Your Ref: OWPC21313
Our Ref: LU/379/18/RES 03-01-2019
Please ask for:
Michael Eastham

Approval of reserved matters following outline consent LU/47/11/ for 50 No. dwellings.
This application may affect the setting of a listed building.

Parcel A2/B6 Hampton Park Toddington Lane Littlehampton

Drawing Title:
External Works Plan

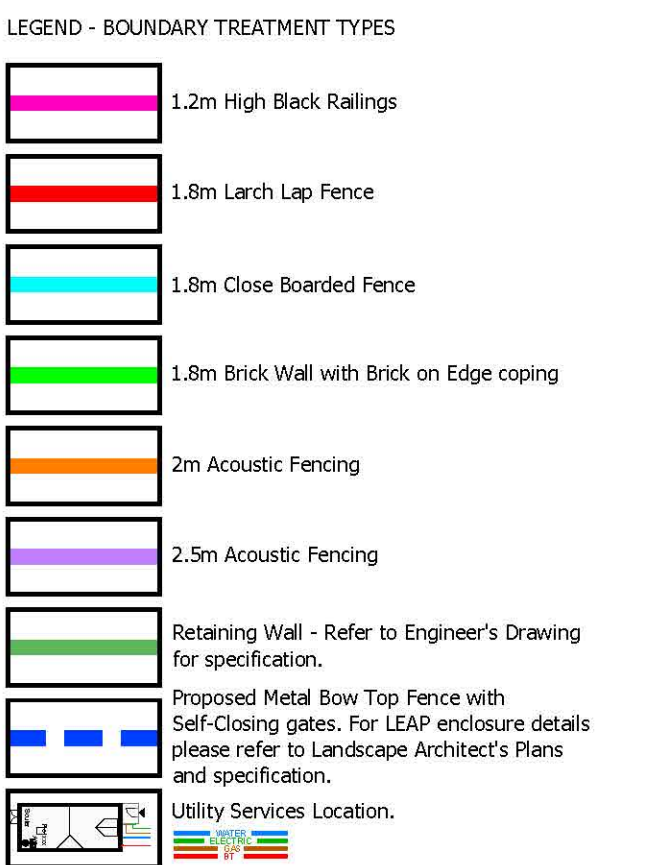
I am concerned that as far as I can see, no visual or verbal reference is made to the 2 houses that stand on a parcel of land north of the proposed development but on the South side of Mill Lane, 19 & 20 Mill Lane. It appears that when the layout of the site was drawn the developer was completely unaware that these 2 houses existed.

Plot 15 at the North West end of the proposed site appears to stand imposingly close to the boundary fence of the Mill Lane properties, further more the land of the proposed site being approximately 4 to 5 feet higher than 19 & 20 Mill Lane, Plot 15 will be towering over the adjacent site of the Mill Lane properties.

I suggest the developer re-submits a revised layout taking into account the Mill Lane properties giving them due consideration.
